Our Ref: R/246/18/HH
Your Ref:

Town & Country Planning Act 1990 (as amended)
Town & country Planning (Development Management Procedure) (England) Order 2015
Application for Planning Permission for Works or Extension to a Dwelling

Development Removal of conservatory and construction of single storey extension, internal re-ordering and associated works
Location 53 Park Drive Rustington

West Elevation: Scale 1:100

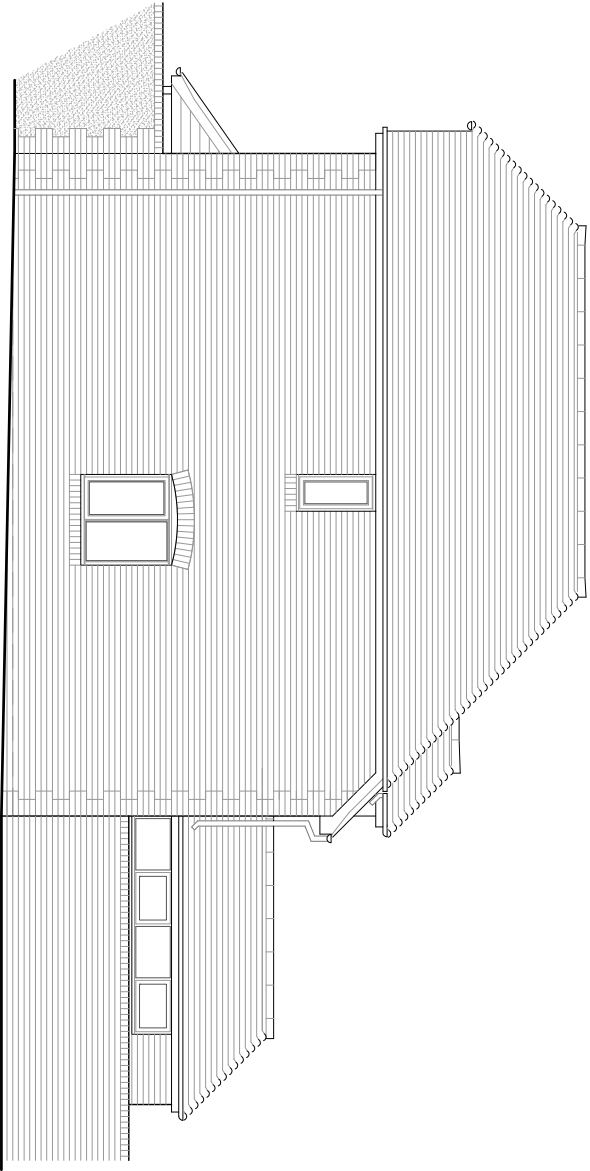
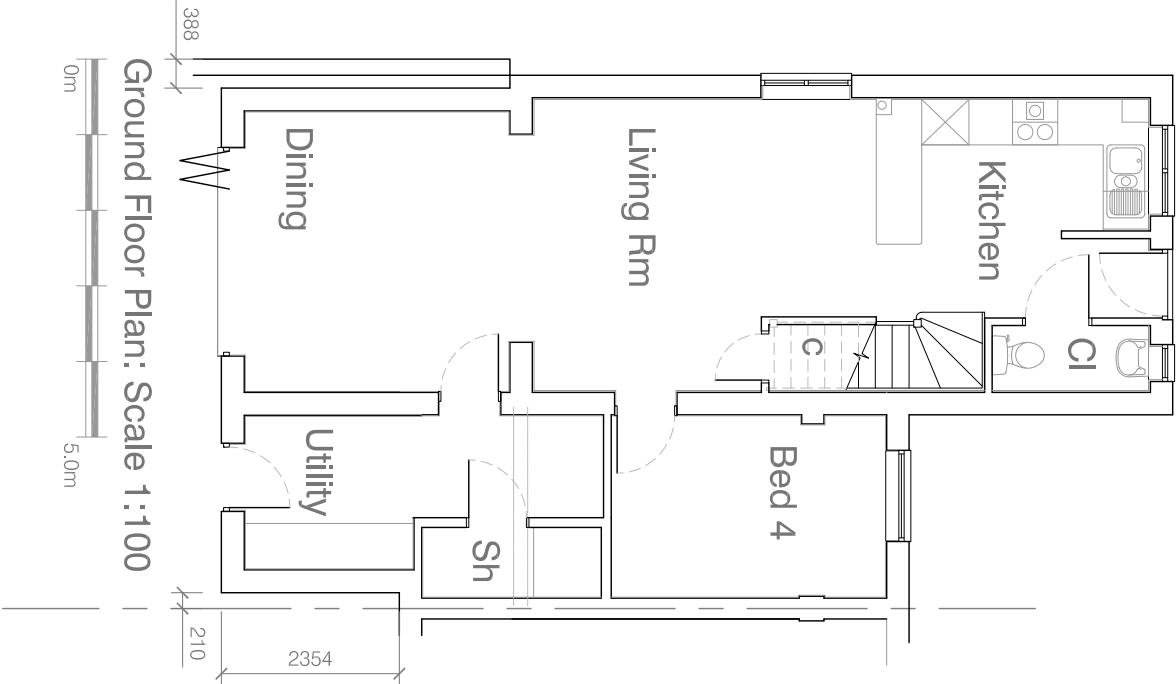
Confirmation required: Please confirm whether the windows on proposed west elevation are high level and if not you are required to show them on the proposed ground floor plan.
